ENVIRONMENTAL STATEMENT FURTHER INFORMATION

**Appendix 1: Regulation 22
request from Cherwell District
Council – dated 09 February
2016**

From: [Matthew Parry](#)
To: [Francesca Robinson](#)
Subject: Land at Wykham Park Farm, Banbury - Ref: 14/01932/OUT
Date: 09 February 2016 16:56:03

| Wykham Park Farm Parameter Plan | |

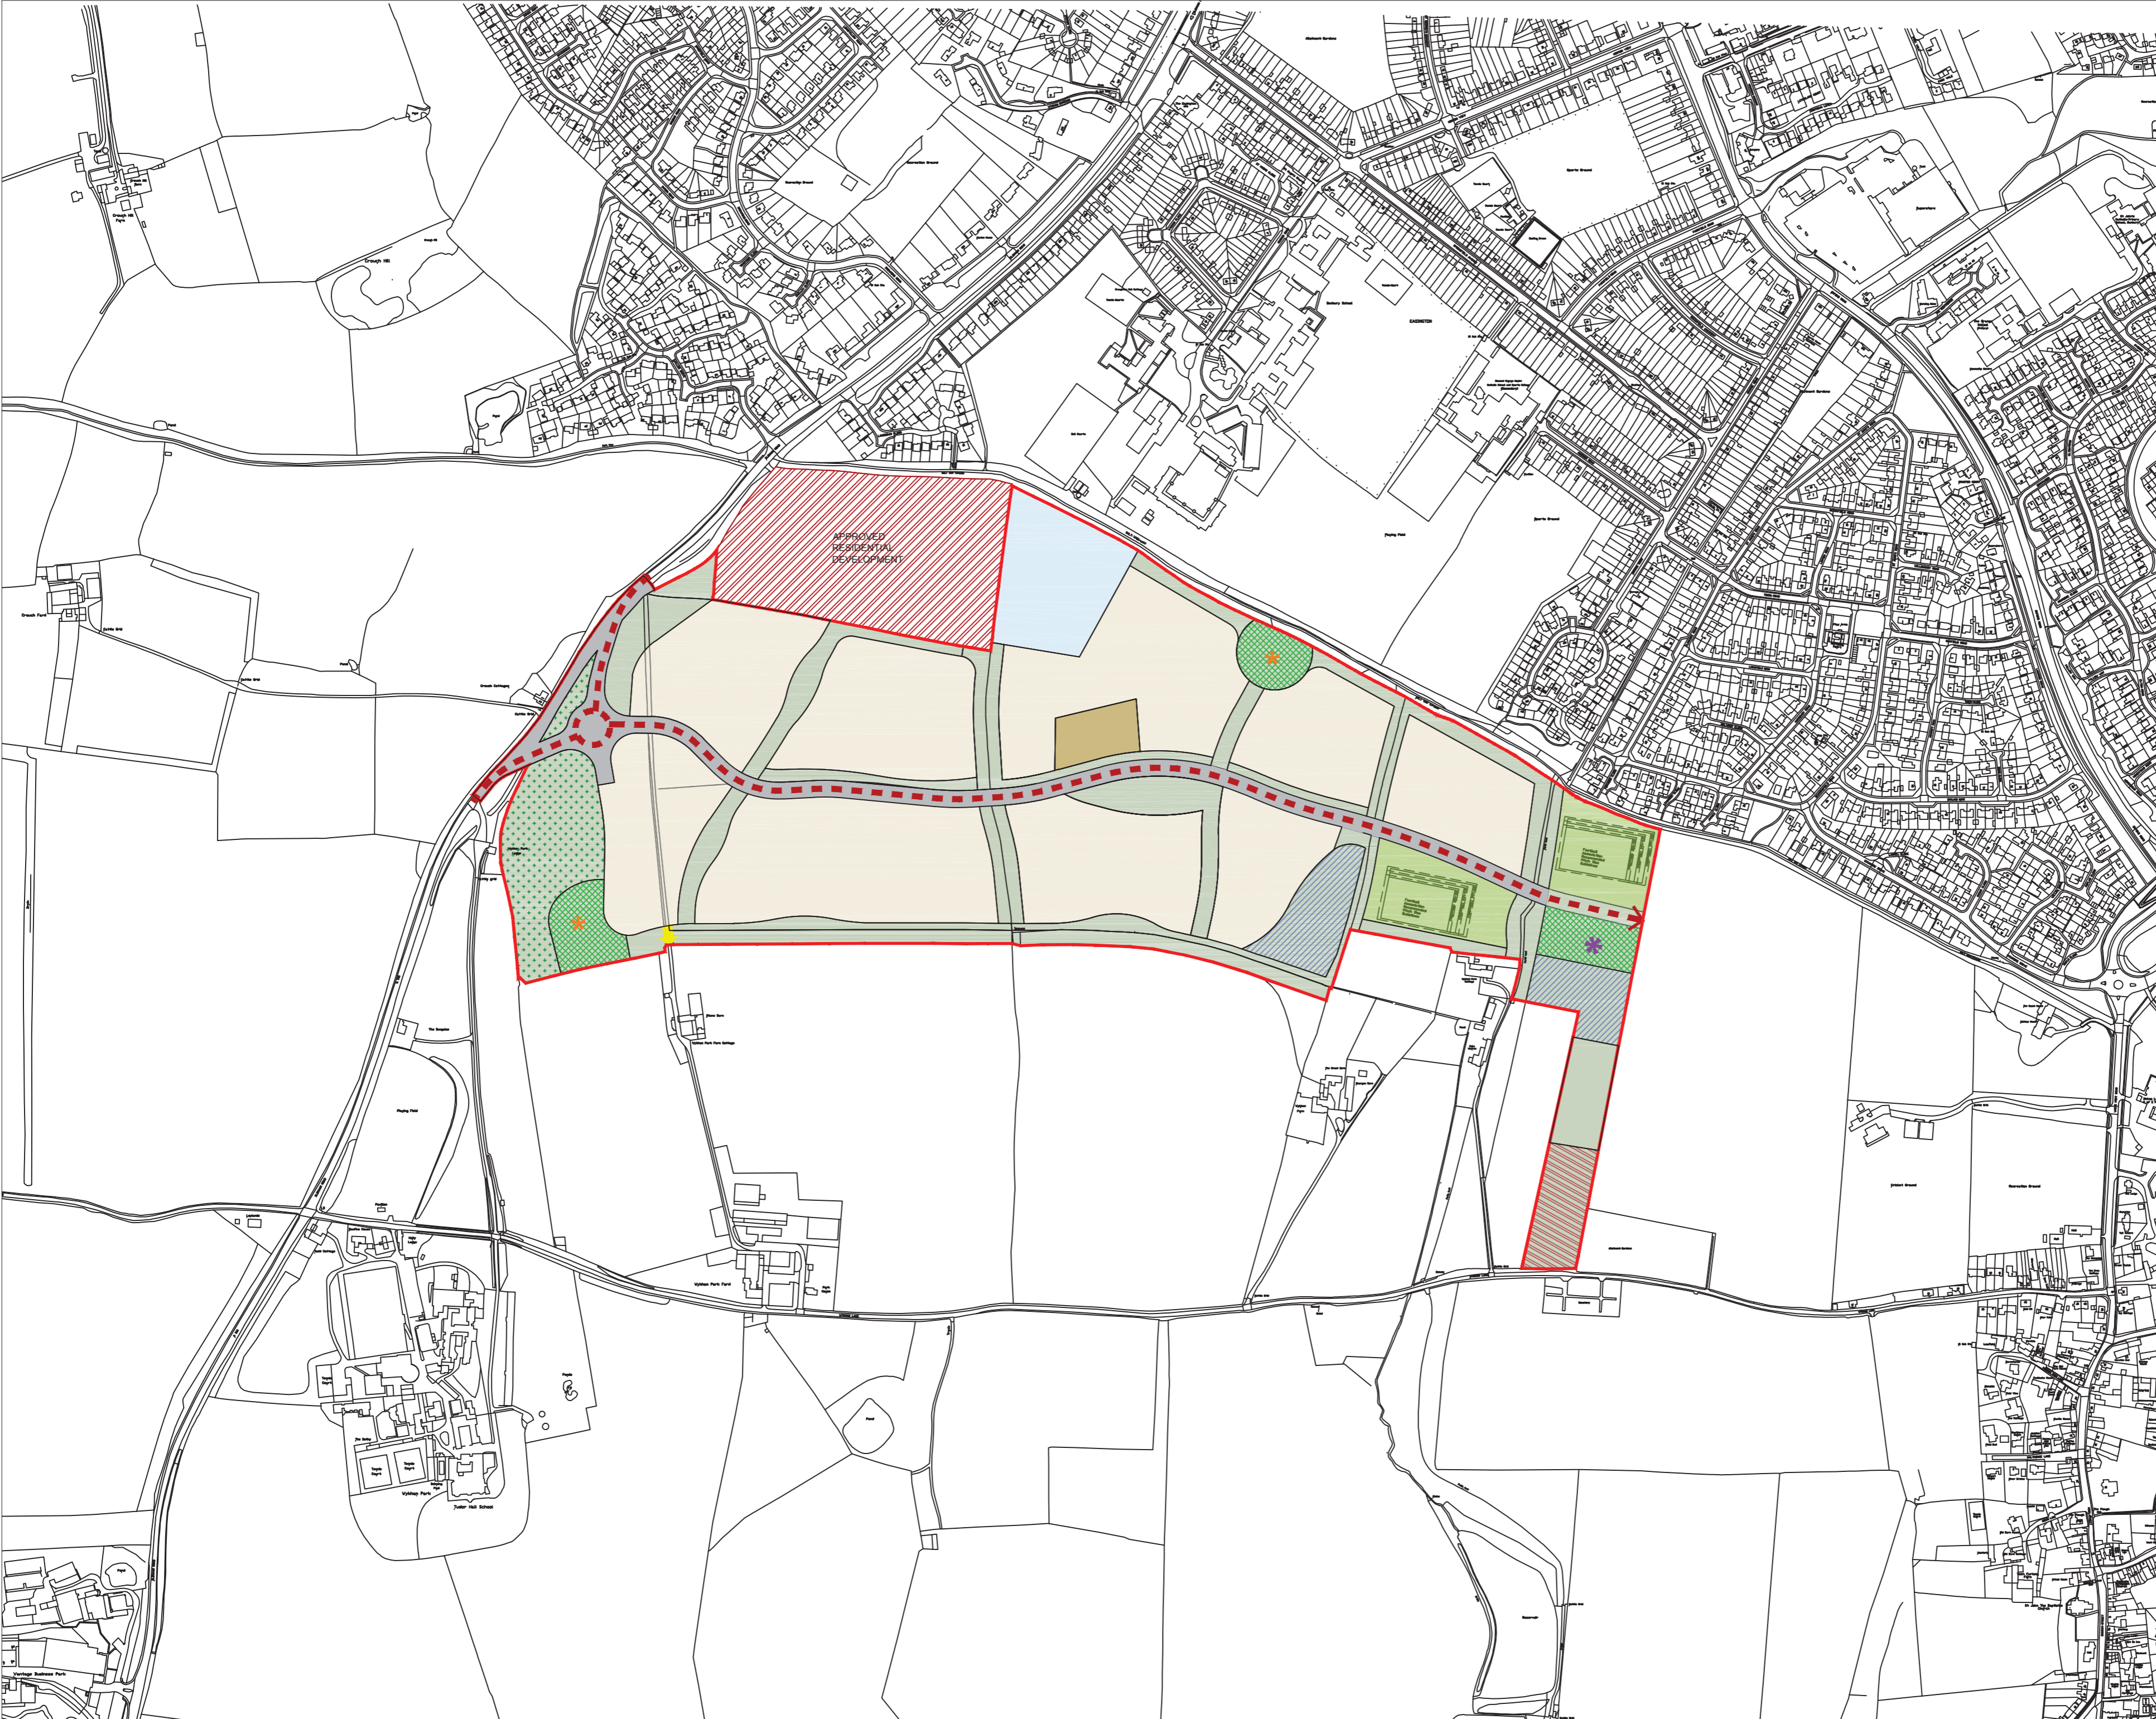
- The ES references an internal road layout that differs from that being proposed as part of the application and is too small to reflect that required for a spine road. This should be addressed.
